CITY OF ALBUQUERQUE

July 17, 2018

Site: Guardian Storage-La Orilla

Re: Drainage Ordinance (14-5-2-1) Violations for Erosion and Sediment Control and Construction Site Waste(s)

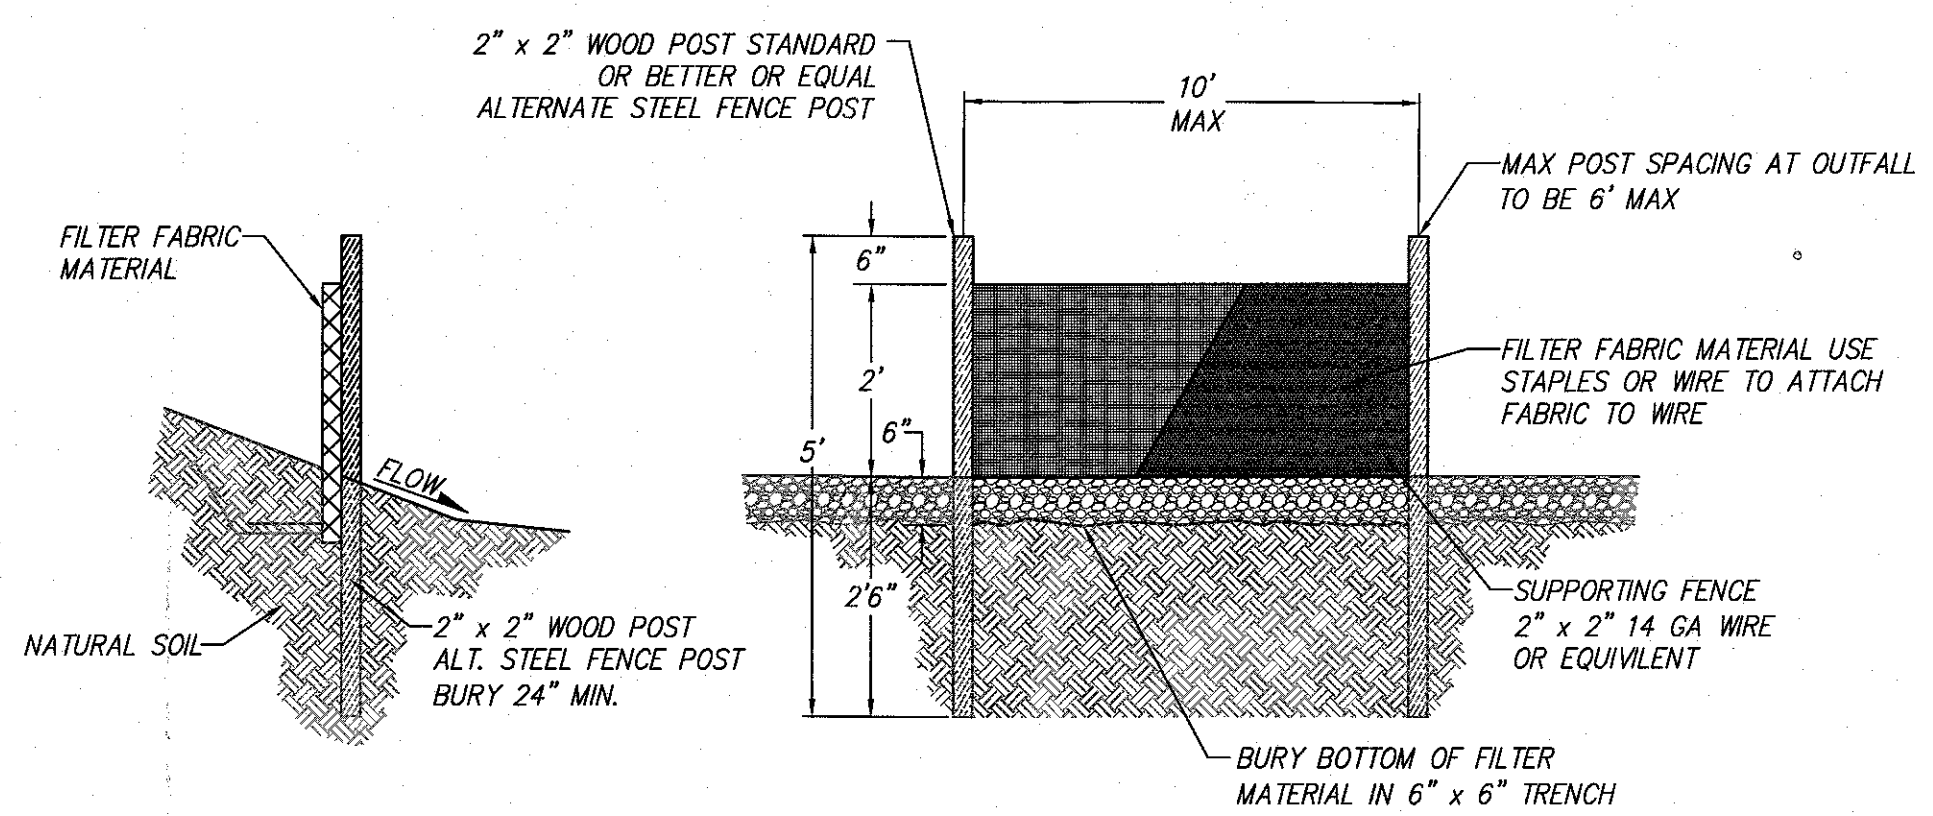
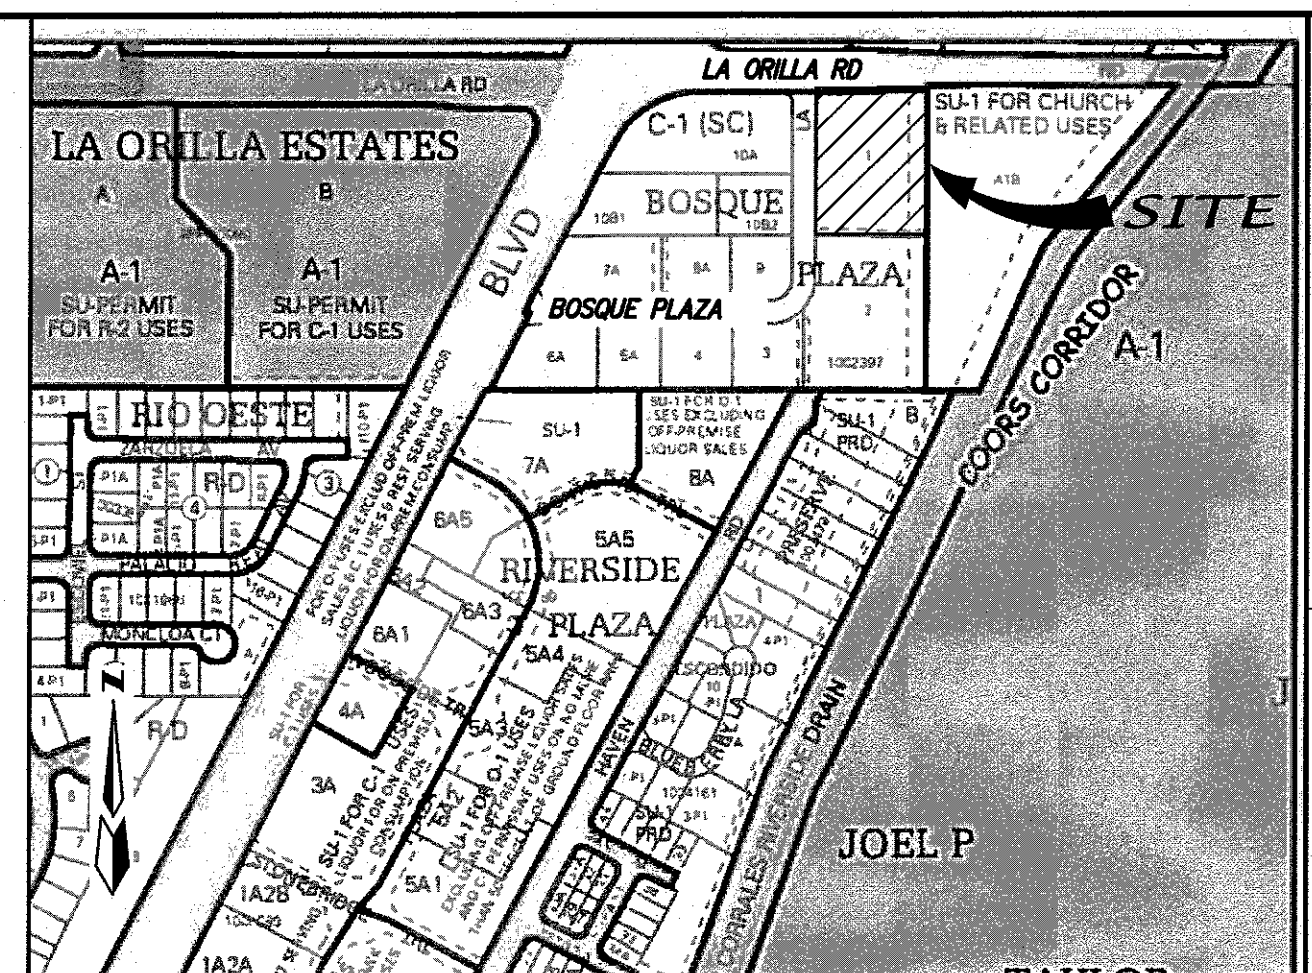
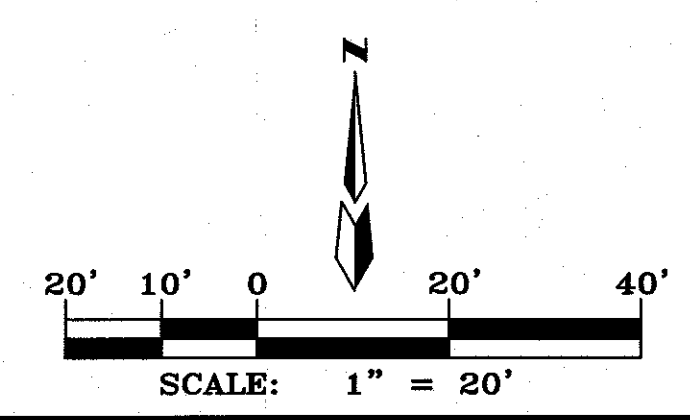
1. Trash was observed leaving the site in the southeast corner.
2. Track-out onto Lo Orilla Rd.
3. Track-out onto Bosque Plaza Lane that is contributing to track-out onto La Orilla Rd.
4. Track-out pad requires maintenance/replacement. Workers are exiting a muddy site with a track-out pad in poor condition.
5. Construction site waste (cement material) on La Orilla Rd and Bosque Plaza Lane.
6. A section of silt fence was removed apparently for the delivery of cement.
7. Wash-out in the dirt. This area drains to the northeast corner where the silt fence is not buried.
8. No acceptable wash-out facility onsite.
9. The silt fence is not buried in the northeast corner. This is currently a discharge point.

1. Remove trash that has left the site and trash in the SE area that could leave the site. Deposit trash into an appropriate container.
2. Remove track-out from Lo Orilla Rd. It extends up to Coors Blvd
3. Remove sediment from Bosque Plaza Lane.
4. Perform maintenance/replace the track-out pad.
5. Remove the cement material from La Orilla Rd and Bosque Plaza Lane. Material is not to be washed into the bosque. An aqueous solution or similar may be used to help remove it, but it must be captured/treated.
6. Replace the section of silt fence that was apparently removed for the delivery of cement.
7. Remove the wash-out from the dirt.
8. Provide an acceptable wash-out facility onsite and have workers use it.
9. Maintain the silt fence in the northeast corner so it is buried. Stormwater quality recommends diverting drainage away from this location.
